January 18, 2019

**RE: Winsome (f.k.a. McCune Ranch) Preliminary Plan (SP-18-006, R1) – 1st Review Response**

This letter responds to your November 13, 2018 review letter relating to the above referenced project. Responses to review comments are shown in **RED** below. Additional comments were received that were not included in your letter and these have also been addressed below.

DATE	9/21/18
SCALE	AS SHOWN
JOB NO.	181459
FIGURE NO.	6

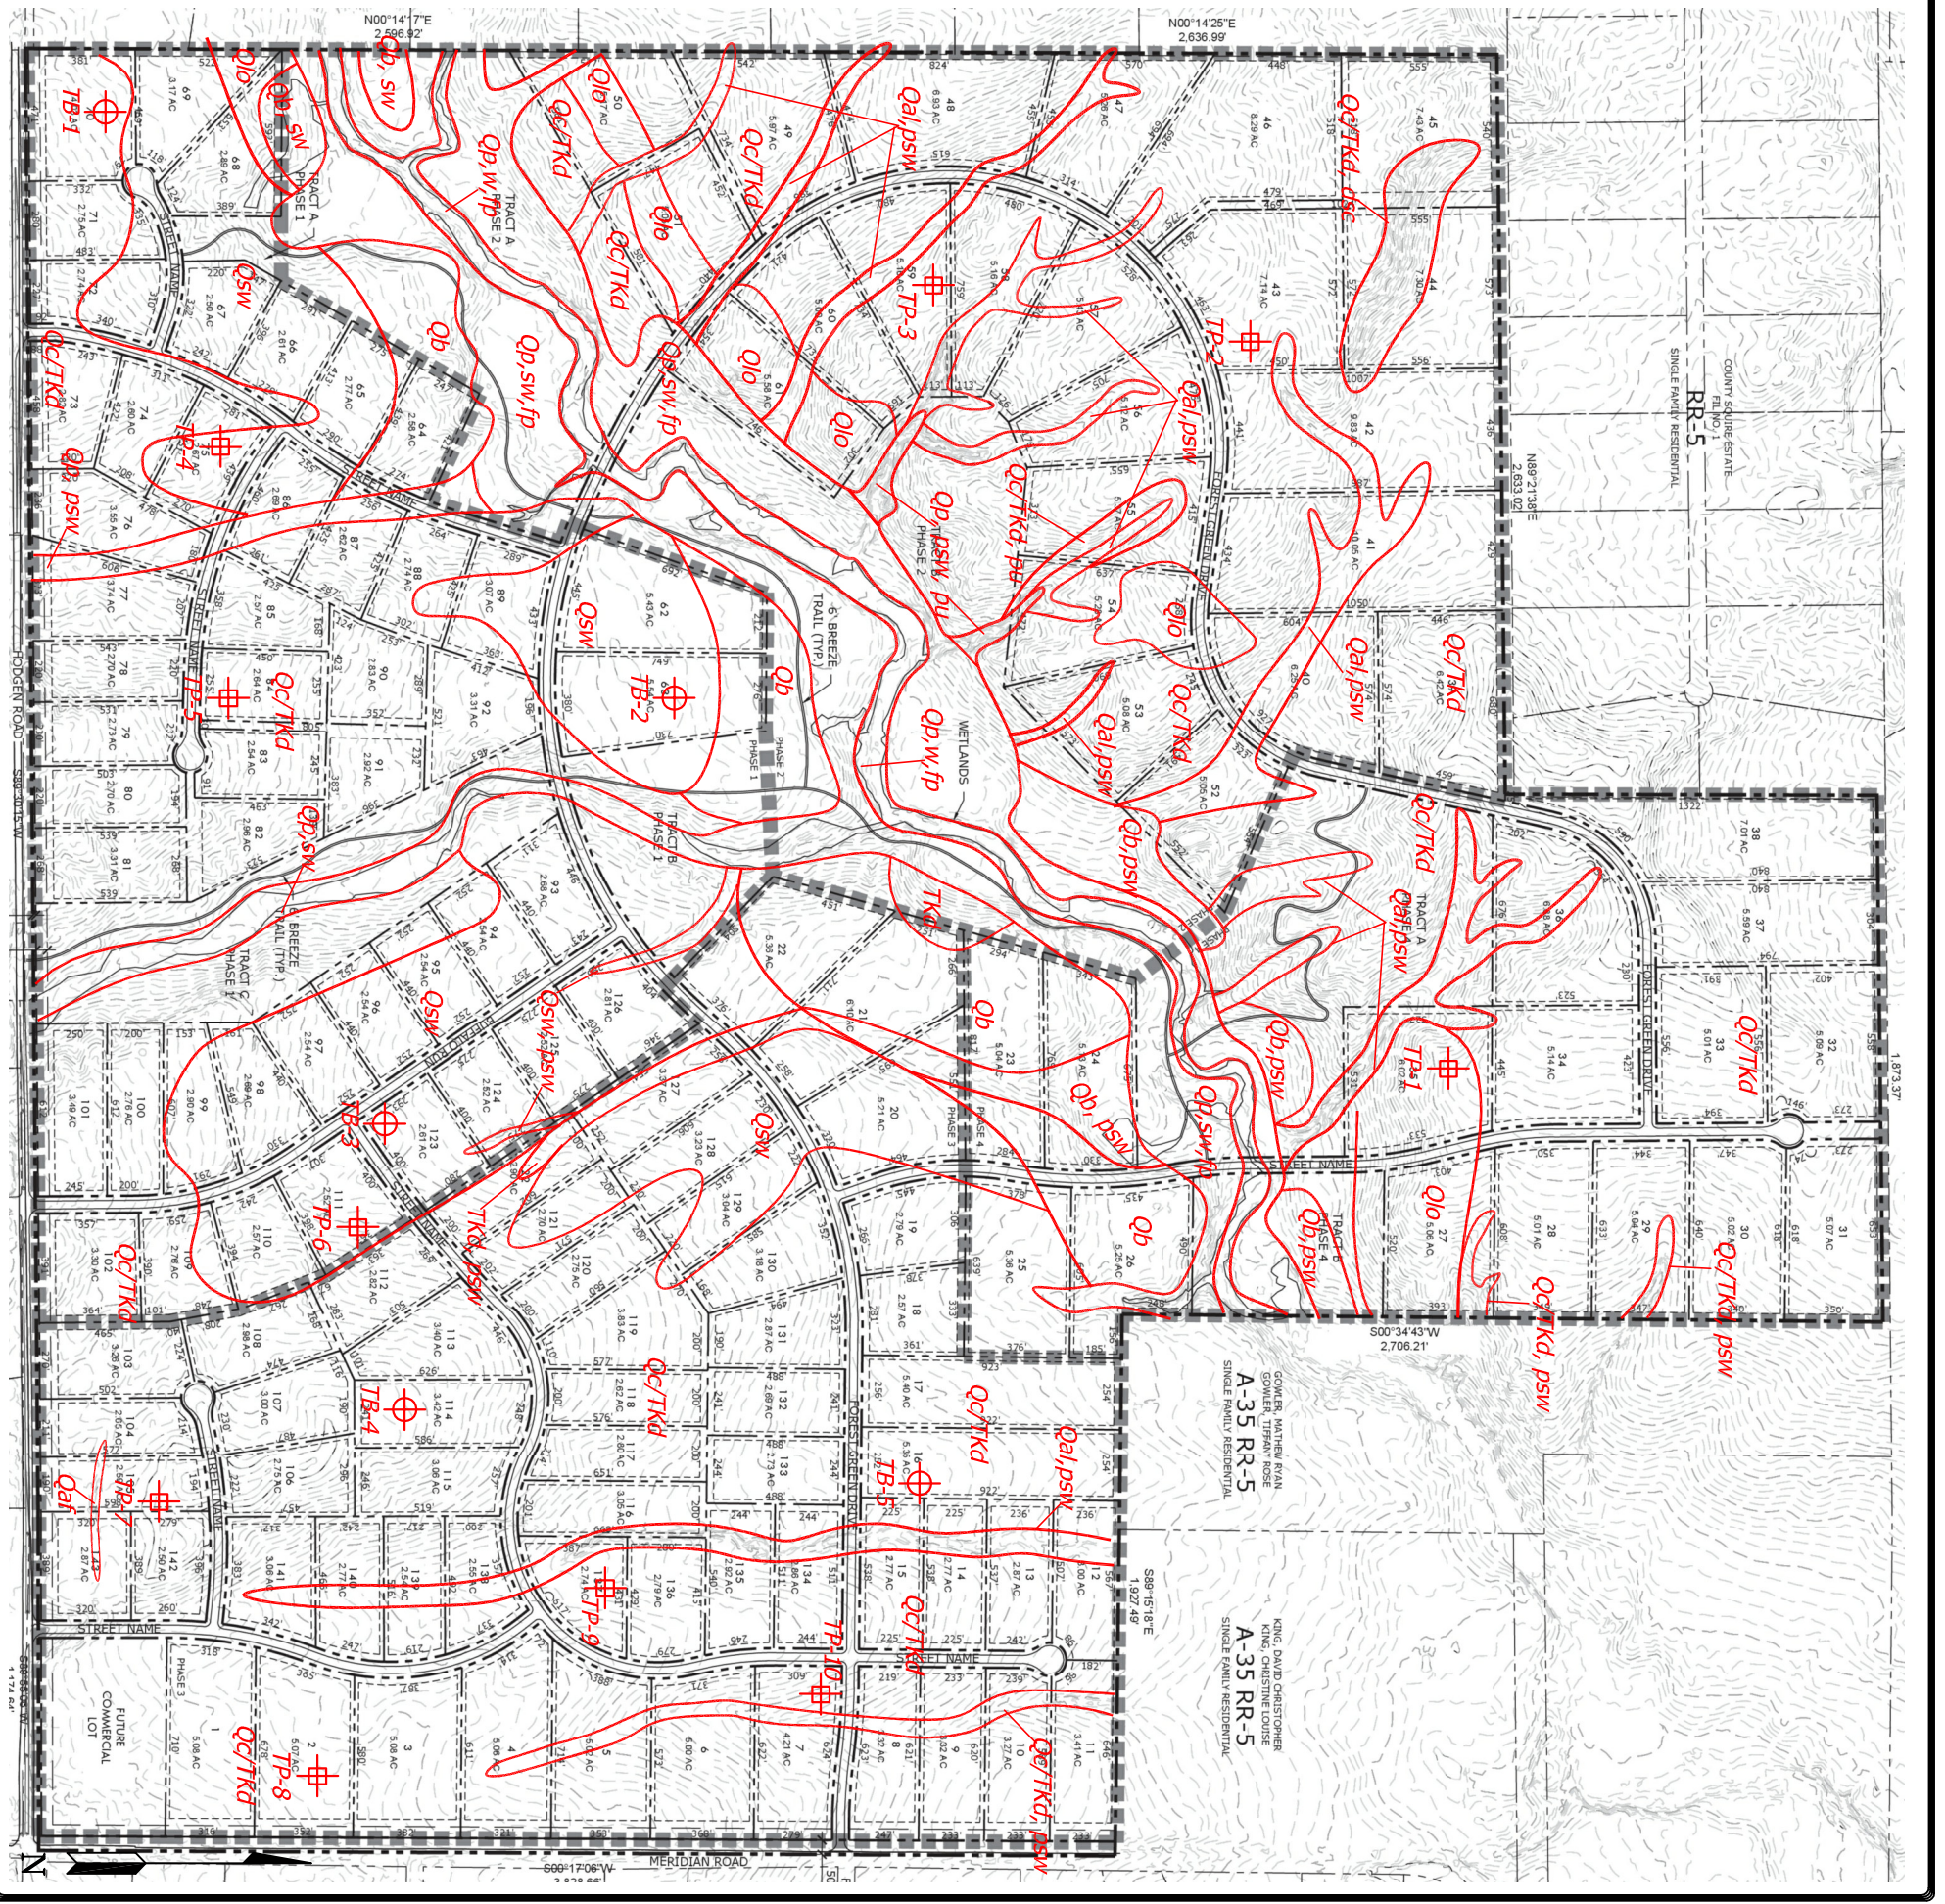
2. There are many areas identified in the soils report as potentially hazardous. The soils report indicates mitigation techniques for this area, which typically calls for specific construction related to the foundations. These areas are not all called out on the preliminary plan as no build. It appears as though the intention is to require an engineered foundation and/or site plan with each site plan review. **Not all constraints warrant no build restrictions and those areas that are recommended as such in the Soils Report are identified as no build. Elsewhere, engineered site plans will be required to address recommended mitigation techniques. A note has been added to address this.**
